**Consultation Response from Mike Hibbert,
KC Waste Strategy(Refuse & Recycling)**

2023/90488 Land north of, Halifax Road, Hartshead Moor, Cleckheaton, BD19 6PE

Demolition of existing buildings, erection of 9 dwellings and alterations to convert existing barn to 1 dwelling

Responding Ref: WPN 23-016

P 100 revision B
PROPOSED SITE PLAN

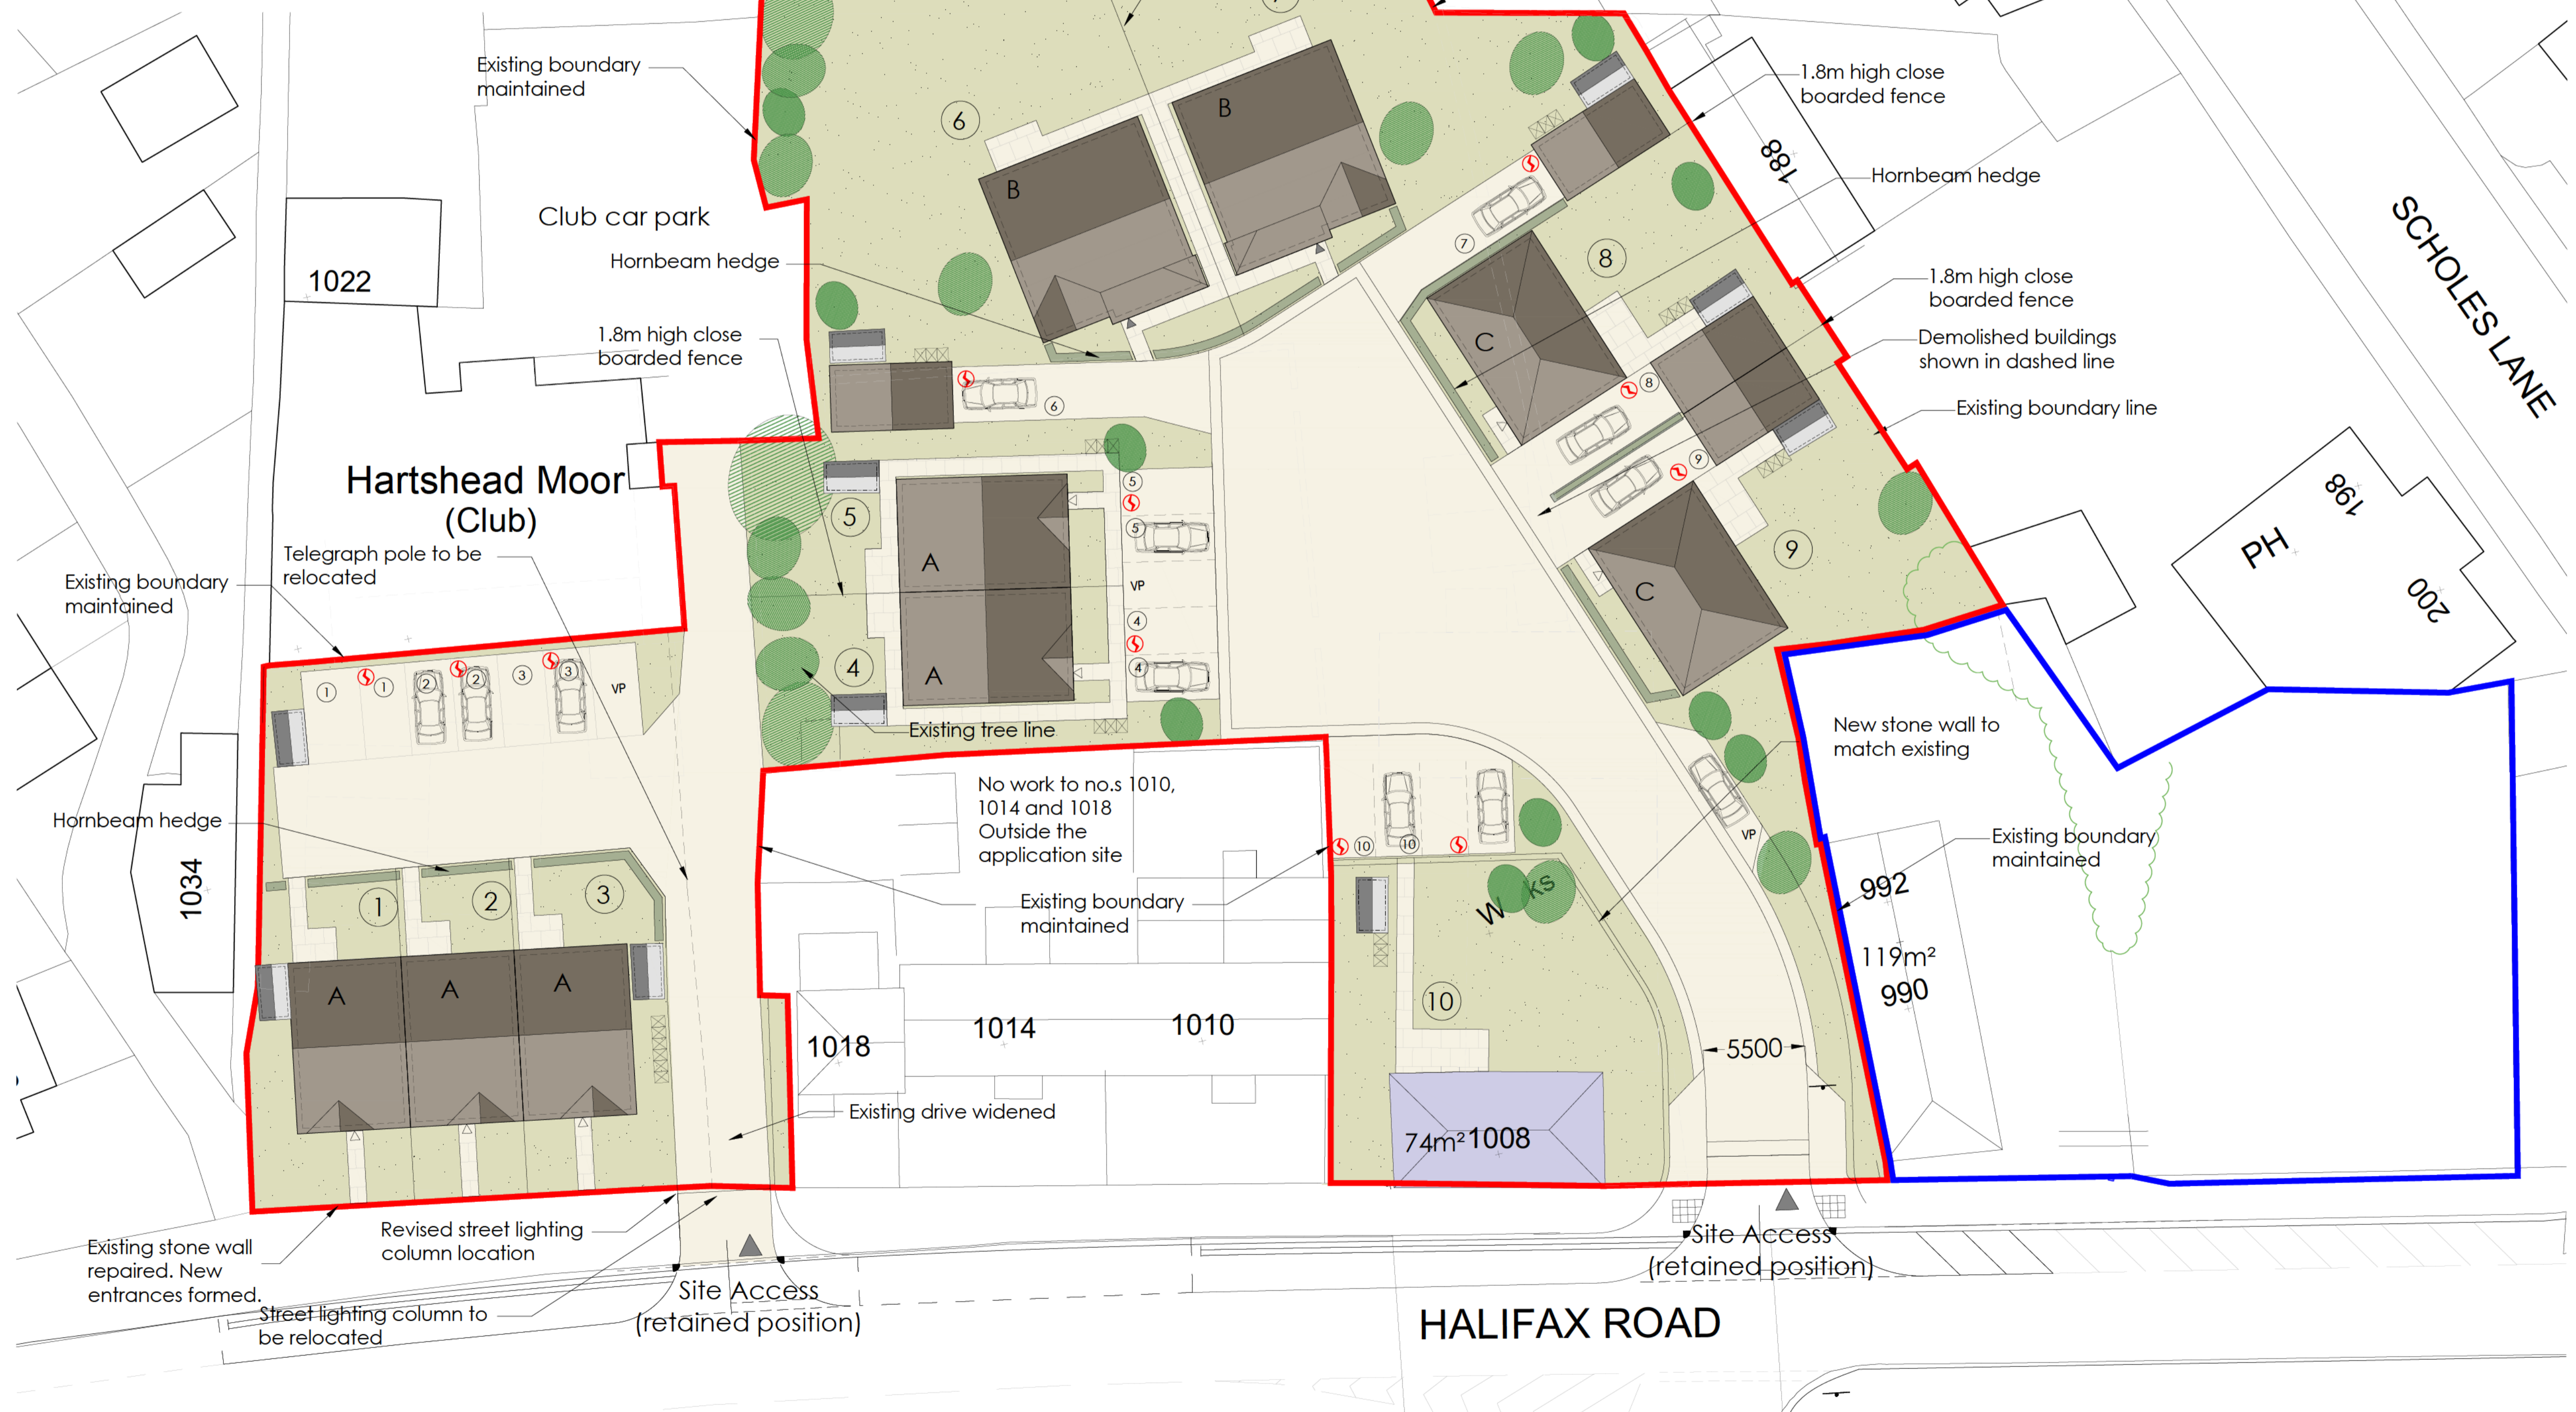
The applicant has submitted Proposed Site Plan P100 Rev C dated 30.01.2023 that is annotated with the location of bin stores at each property and a Design and Access Statement H-20078 Rev A - 2023.01.30. that in Chapter 4 page 12 states "Refuse Collection Access Refuse connection for the two vehicle entrances: Western access A bin collection point has been included, located within 25m from the A649 Halifax Road running carriageway and is within 35m of all plots in order to comply with national guidance set out within Manual for Streets (MfS). Central access Bin presentation points are indicated to each dwelling. The proposed adopted entrance allows access for a standard Councils Waste Collection vehicle."

- Plots 1-3 consists of a terrace with private gardens to the rear. Bin storage is shown between the western access road and the gable end of the Plot 3. Preference is for storage of waste bins in rear gardens with residents presenting bins at a Bin Collection Point (BCP) on collection day.
- Space will be required for 3 x 240ltr bins for each property, 1x240ltr Residual, 1x240ltr Recycling and as the properties have gardens the space to accommodate a third bin for garden waste.
- For plots where bin storage is in the rear gardens with gated access that should be shown to be secure and gates wide enough to pass through.
- The proposed bin storage adjacent to Plot 3 would be set within the Streetscene and therefore should be screened and secured to prevent bin blight, the spread of waste into the street, unauthorised use and theft/damage to bins.

- The maximum drag out distance stated in guidance from properties to a Bin Collection Point should be 25m. Either Plot 1 could present on the Halifax Road in front of the property or although with a longer drag distance a BCP for plots 1-3 could be located on the verge at the side of the Western access road.

- Communal presentation points for bins must be large enough for the number of bins to be collected and be on level, hard surfaces such that grouped bins do not cause obstruction to the highway, drives or pedestrian movement on collection day.

- Plots 4 and 5 should preferably have bin storage located in the rear gardens rather than to the front of the properties.
- Arrangements for bin storage on Plots 6-10 are acceptable.

- For Plots 4-10 there is no indication of space for the presentation of bins on collection day. It is important to ensure that bins do not cause obstruction to pedestrians or other highway users when presented for collection, particularly where space requires these to be left in clusters. Bin presentation space should be identified for each plot, on a hard surface and where a refuse collection vehicle (RCV) can be easily reached.
